From: Simon Davis
Sent: 30 August 2019 12:56
To: stephen jupp [REDACTED]
Cc: Christopher Tomkins [REDACTED]
Subject: RE: Rear of 99 A North Bersted Street

the amended permitted scheme for the bungalow - BE/14/17 - has a full hip but the subsequent permission for the adjacent garage - BE/55/18 - is a barn hip

CLIENT	PROJECT	TITLE	SERVICE	DRAWING BY	REVIEWED BY
C TOMKINS	REAR OF 99 NORTH BERSIED STREET	ELEVATIONS	PLANNING	SJ	SJ
			DATE	SCALE	DRAWING NUMBER
			01.02.17	1:100@A3	5C

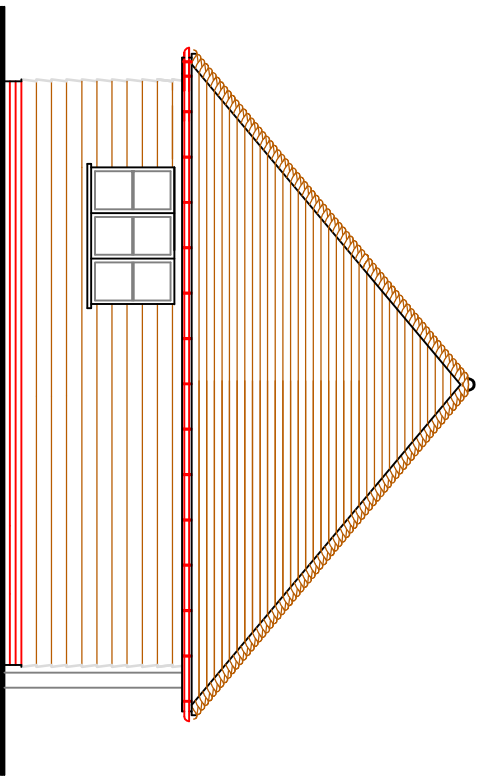
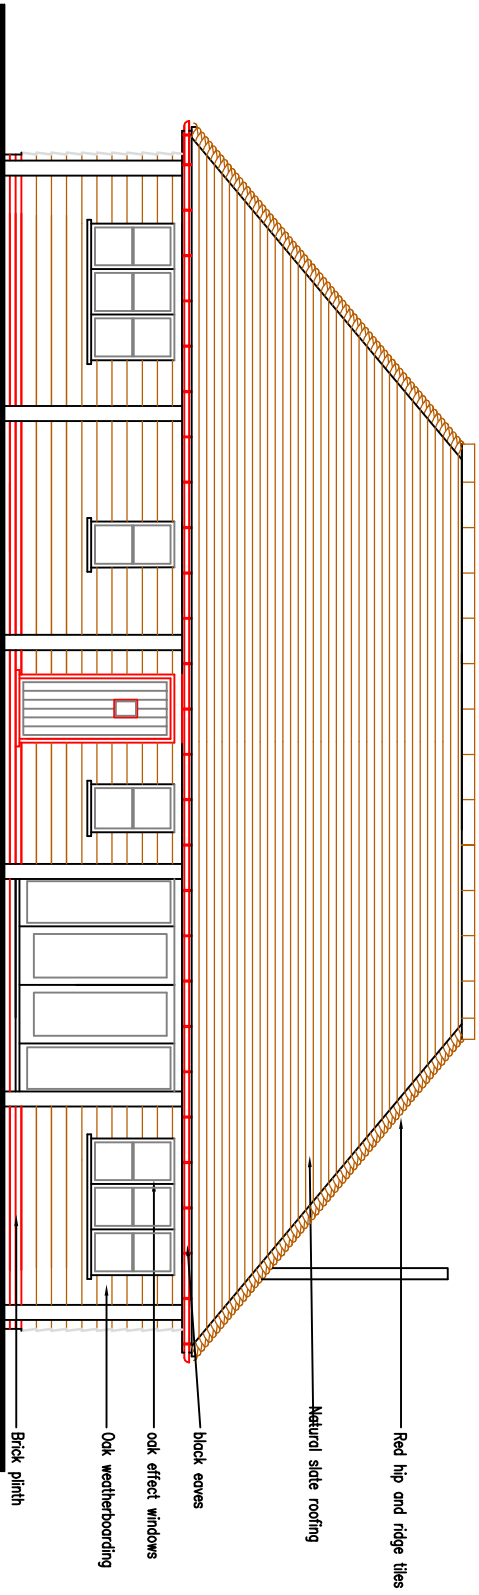
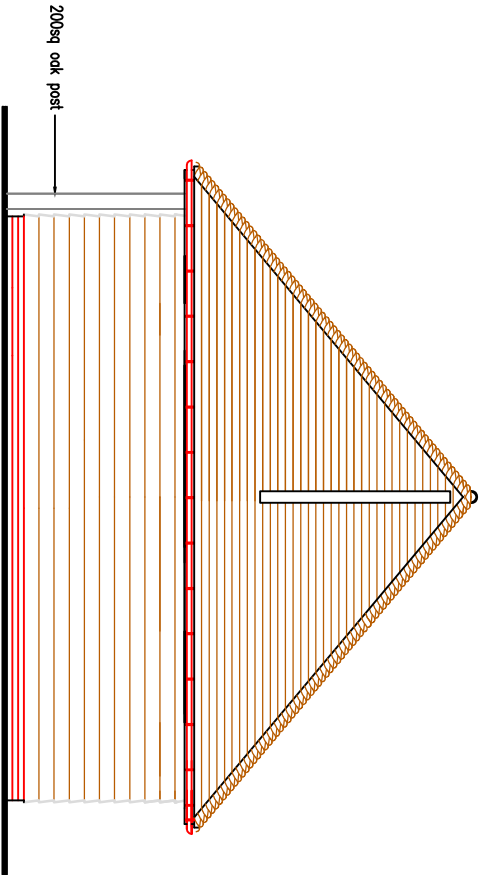
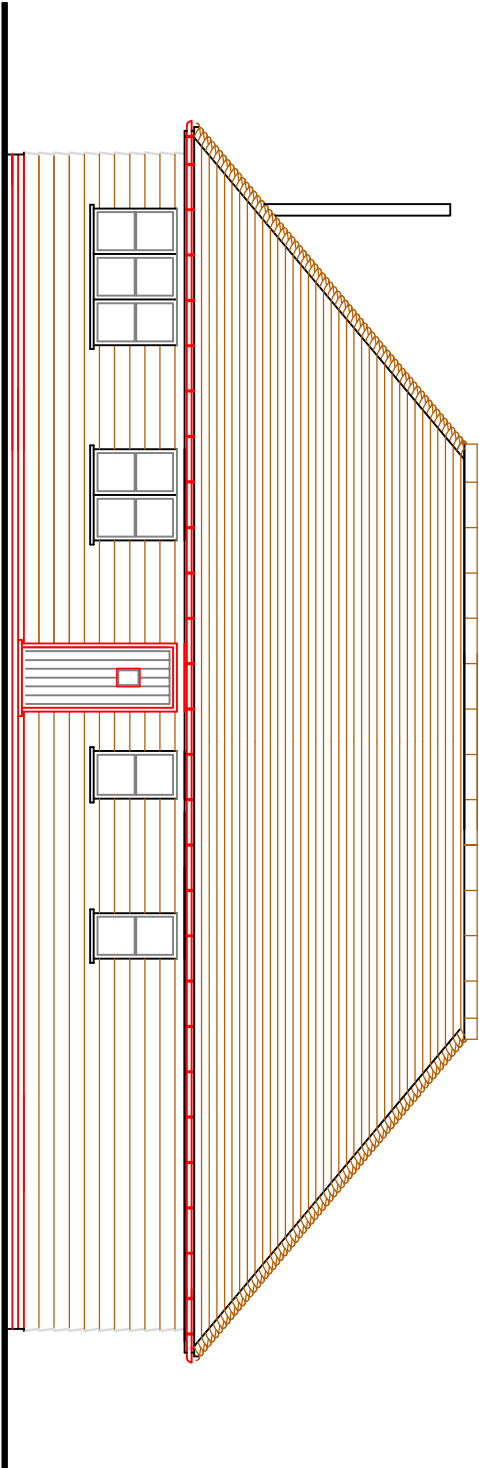
do you think you could agree to us going back to a barn hip on the bungalow in order to provide a coordinated design?

I have spoken with our Conservation Officer, Martin White today and our view is that we would not support the change to the roof of the bungalow. We consider that the difference between the two buildings adds interest value and also respects the rural/historic character.
